RE: Airport Heights Preliminary Plat (LP-09-00008)

WSDOT Aviation has reviewed the Airport Heights Preliminary Plat and offers the following observations and recommendations:

**RE: Airport Heights Preliminary Plat (LP-09-00008)**

Subject: Comment on the Airport Heights Preliminary Plat (LP-09-00008)

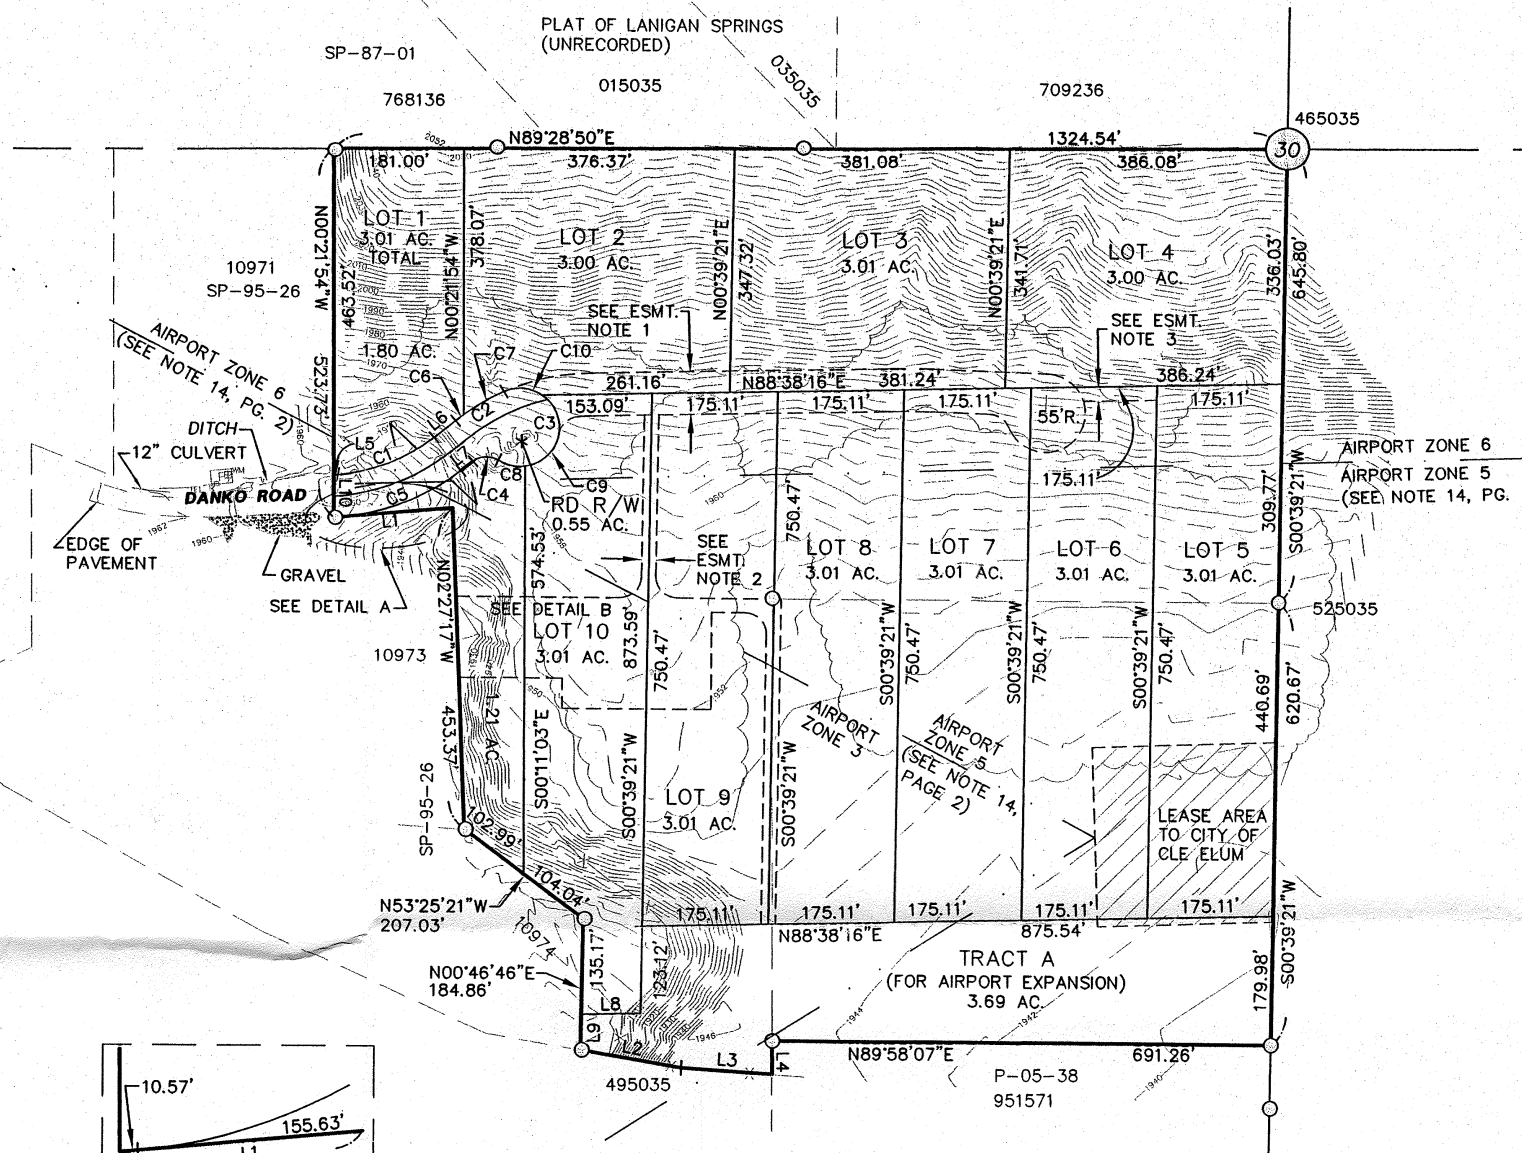
- A. The minimum residential lot size for Agricultural-3 is 1 dwelling unit per 3 acres.
- B. Lot 1 and the unnumbered lot to the south do not meet the minimal lot size requirements of the AG-3 zoning.

- C. Lots 5 and 6 do not meet the minimal lots size requirements as required by RCW 58.17.
- D. RCW 58.17 requires that leased property be subtracted from the total acreage of lots 5 and 6.

- E. The final plat map should:
  1. Reference the adjacent airport property.
  2. Depict the airport's current runway protection zone (RPZ) in lots 5, 6 and 7.

3. Depict the planned 508 foot runway extension and future RPZ (as demonstrated in the 2006 Cle Elum Municipal Airport Layout Plan) in lots 5, 6, 7, 8, 9, 10 and the un-numbered lot.

4. Label the unnumbered lot or tract pursuant to County Codes.
- F. As a condition of approval, we recommend:
  1. All residential structures in lots 5, 6, 7, 8, 9, 10 and the unnumbered lot should be moved as far away as possible from the extended runway centerline. The majority of off-airport property aircraft accidents occur along the extended runway centerline.

2. The proposed residential building footprints should be depicted in the final plat map.
3. All proposed stormwater facilities shall meet both the FAA's and WSDOT's best management practices for aviation related stormwater facilities. Wildlife strikes have killed one hundred ninety-four people and destroyed one hundred sixty-three aircraft according to the *FAA Wildlife Strikes to Civil Aircraft in the United States* between 1990 and 2005.
